facsimile transmittal

To: Mark Chaloupecky **From:** Mike Nugent

Re: 157 York St.

TRUSS DIAGRAMS

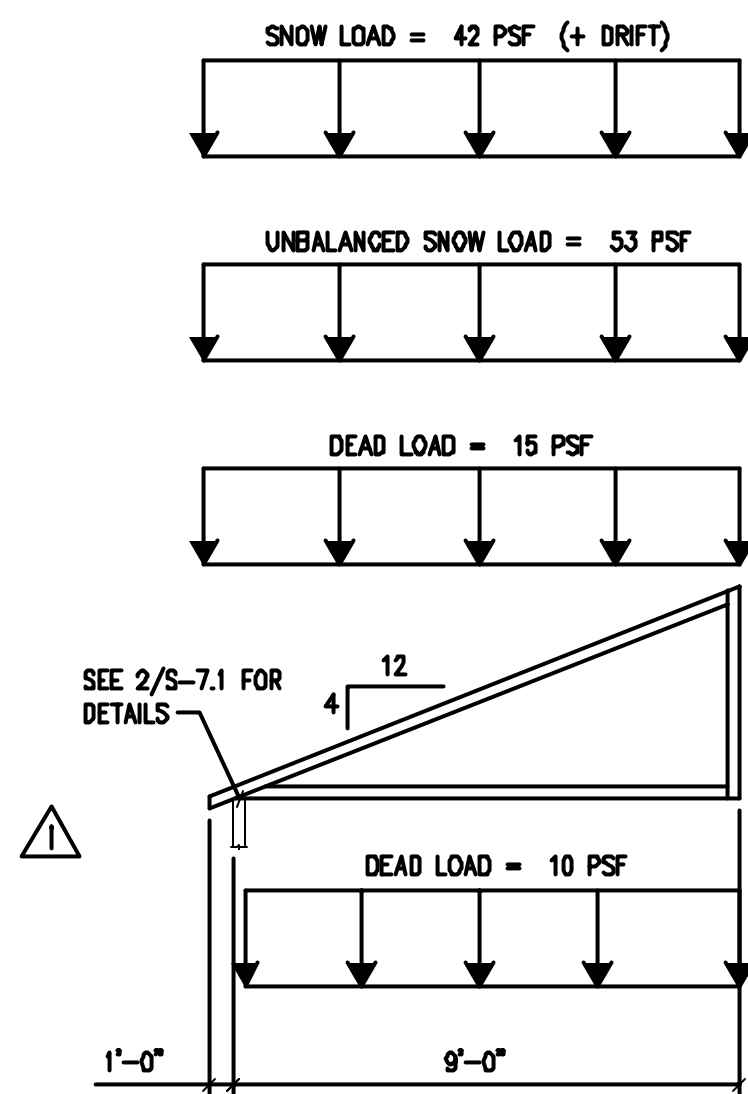
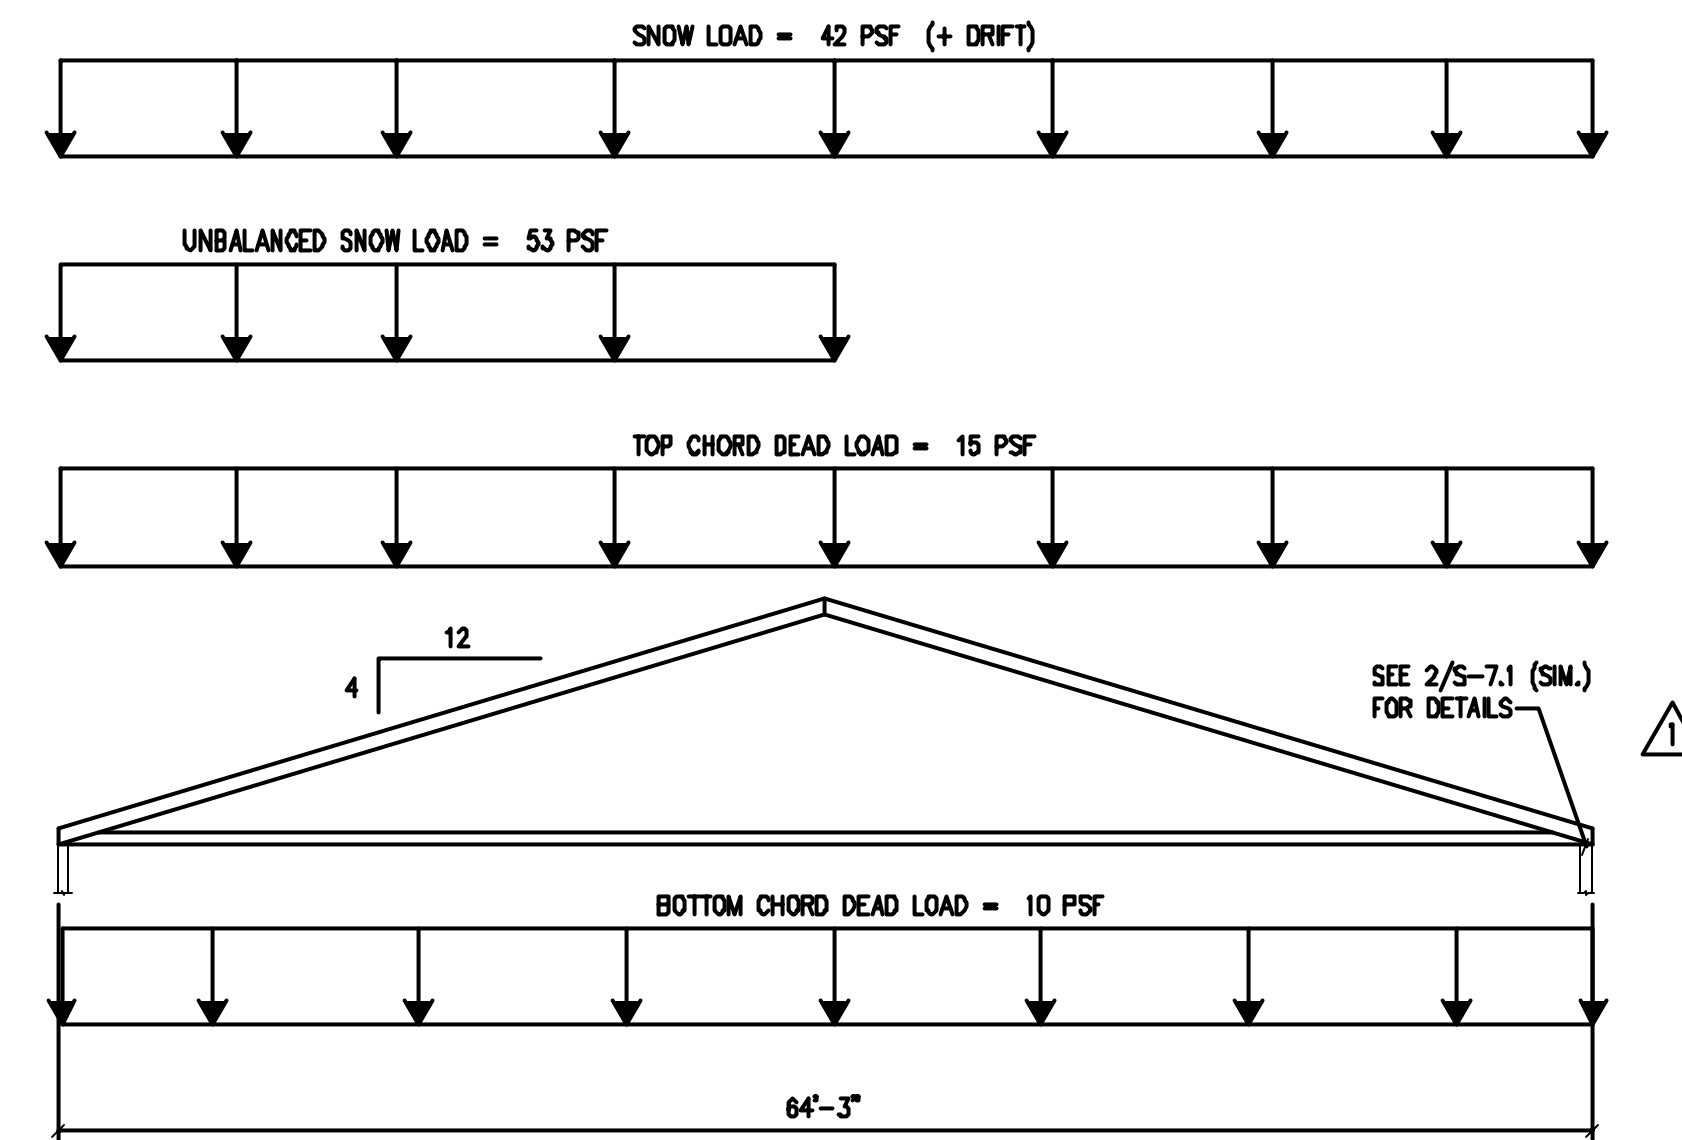
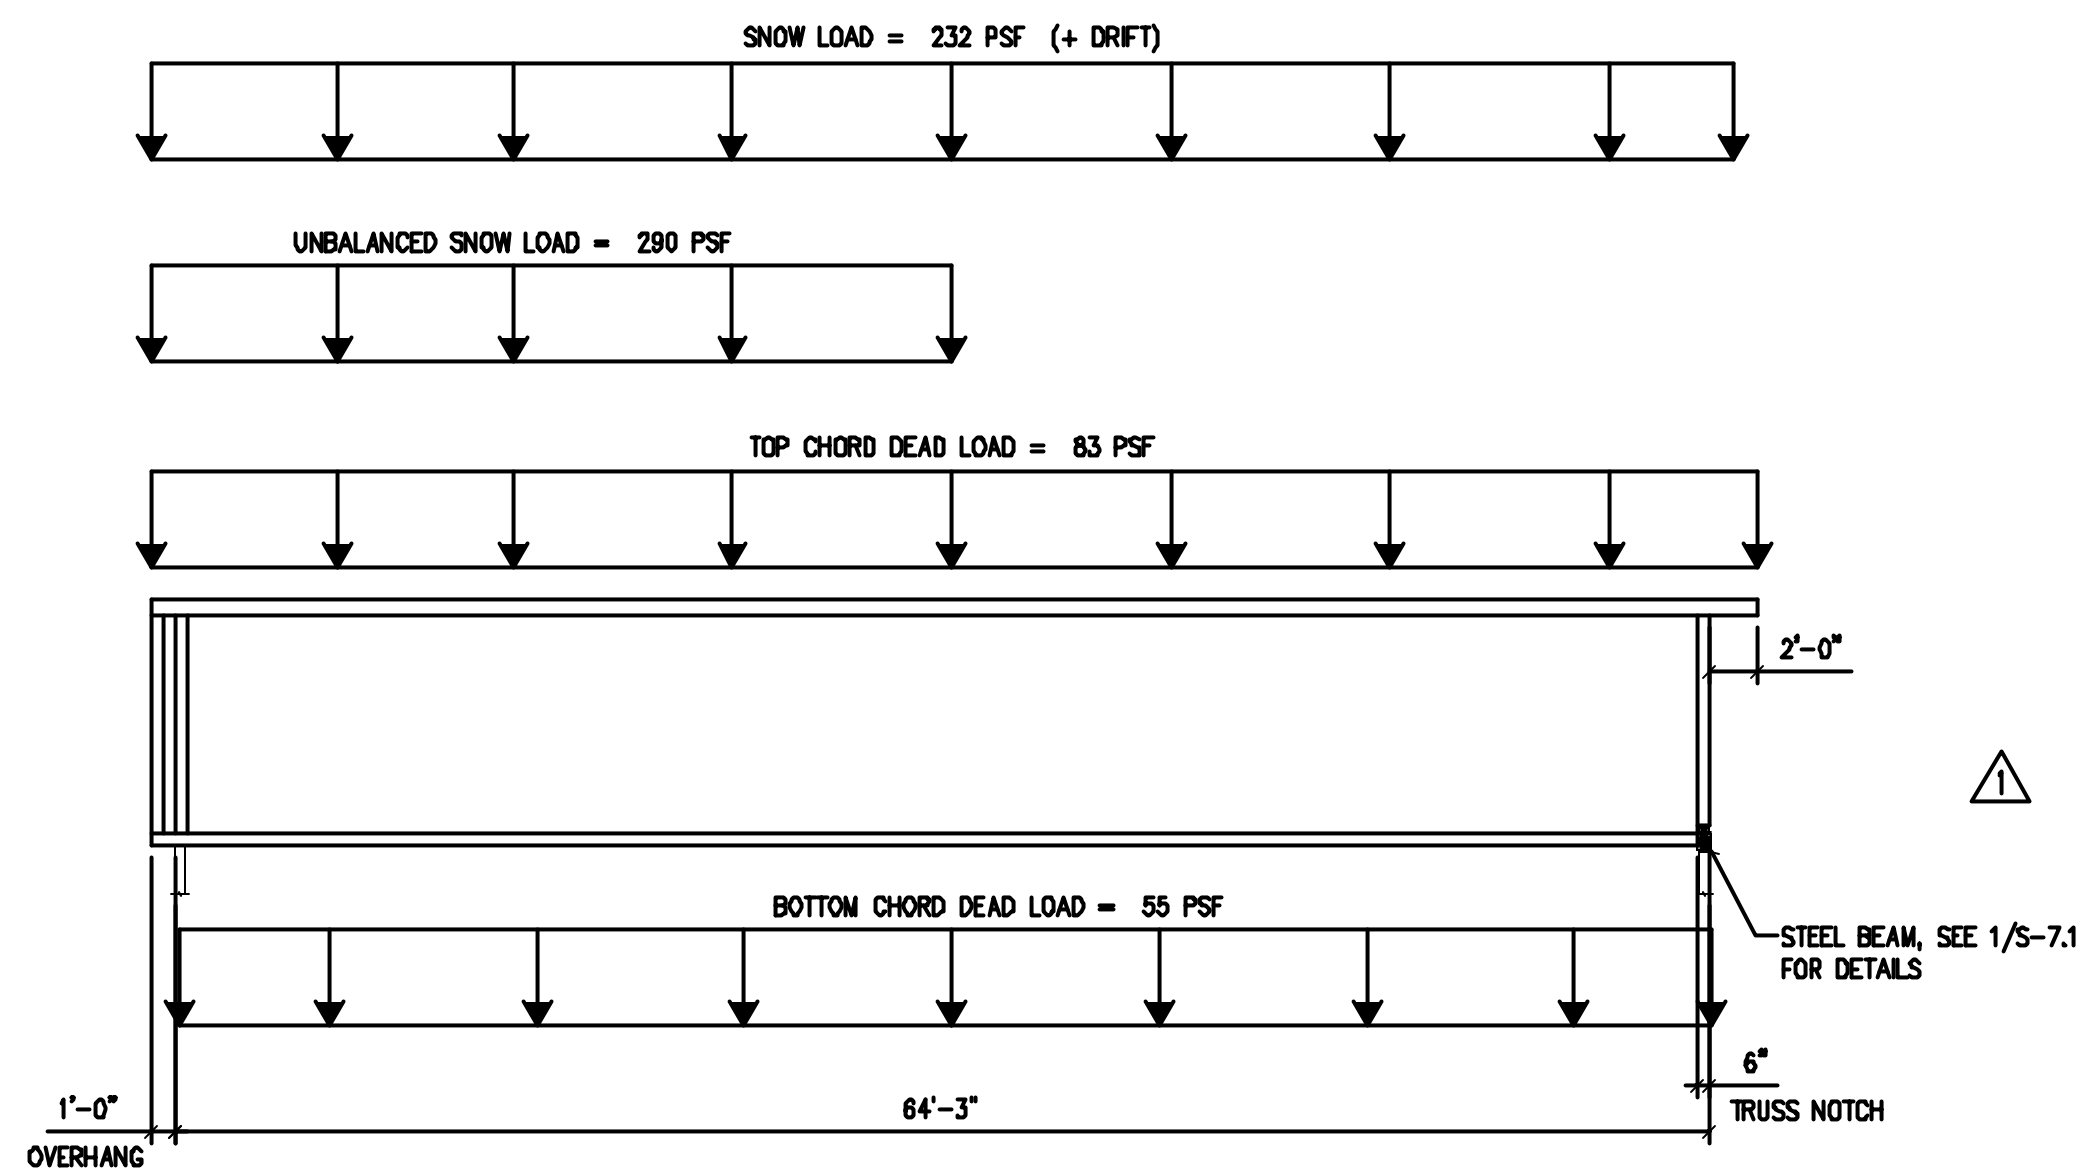
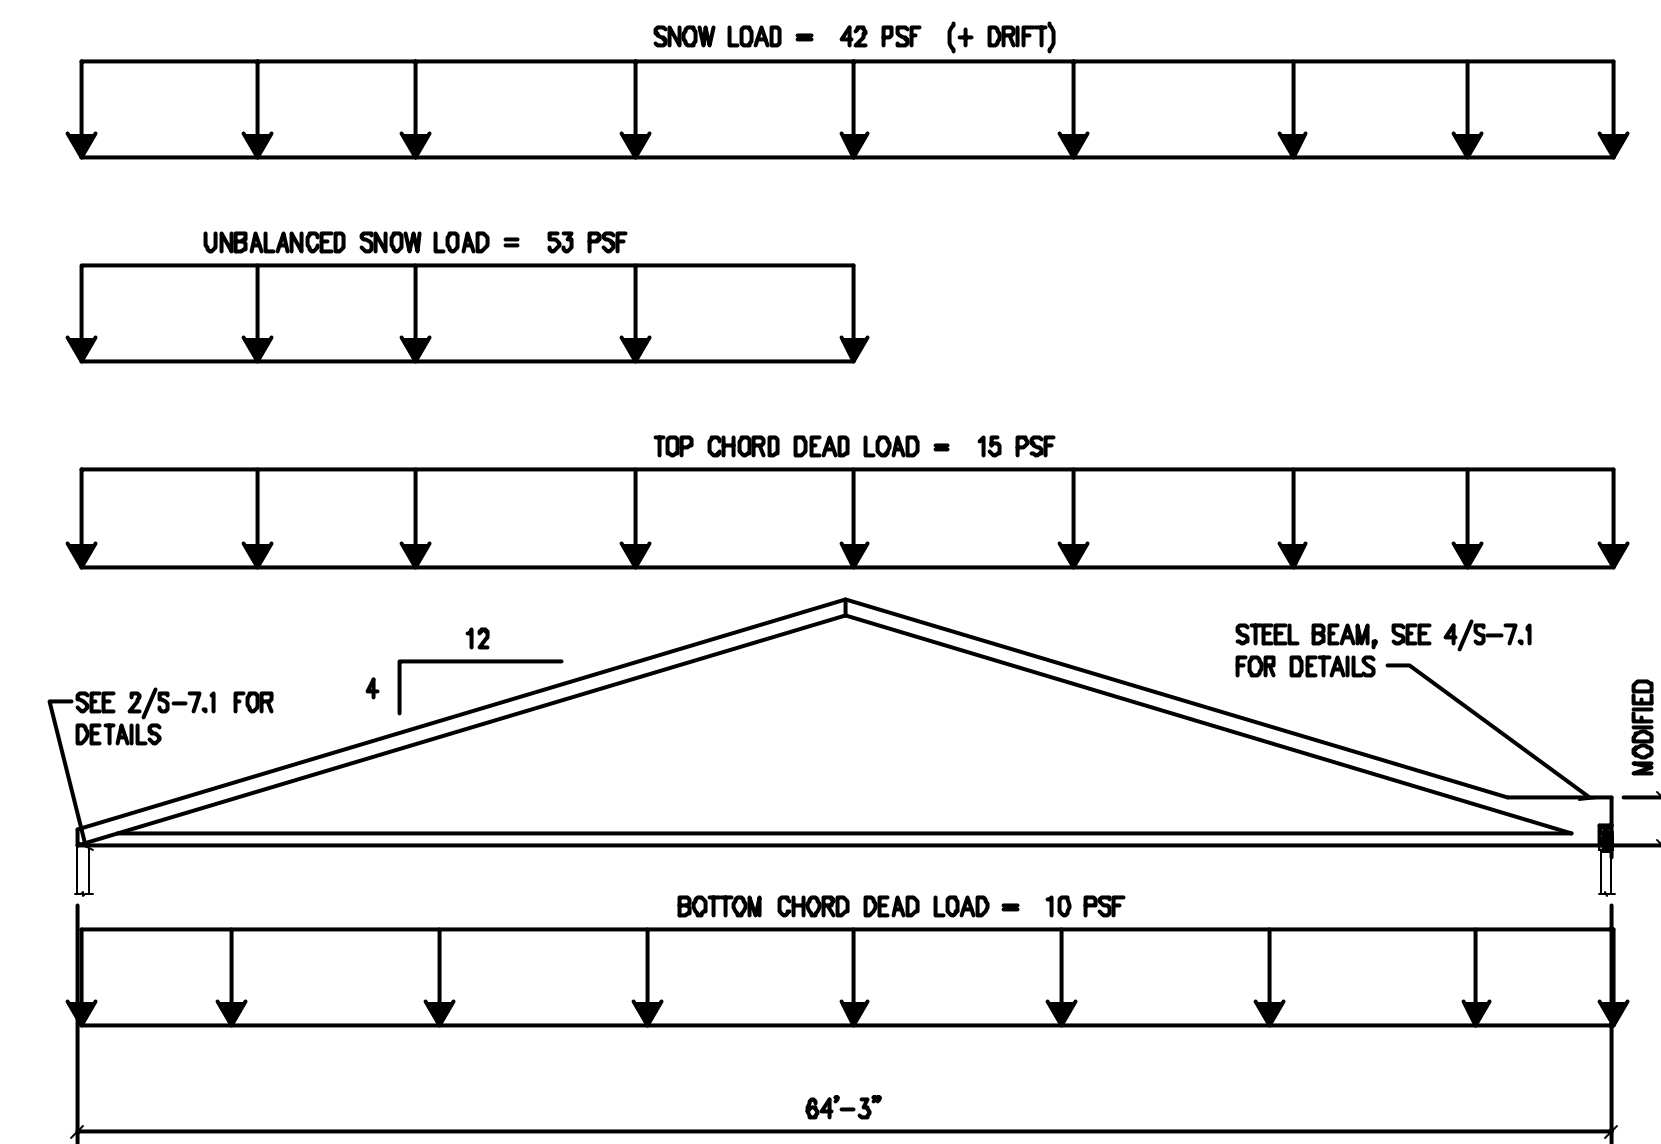
What analysis procedure was used in the seismic design (1610.4 /5)
Were drift loads and sliding snow loads considered for the dormer valleys and the porch
roves.
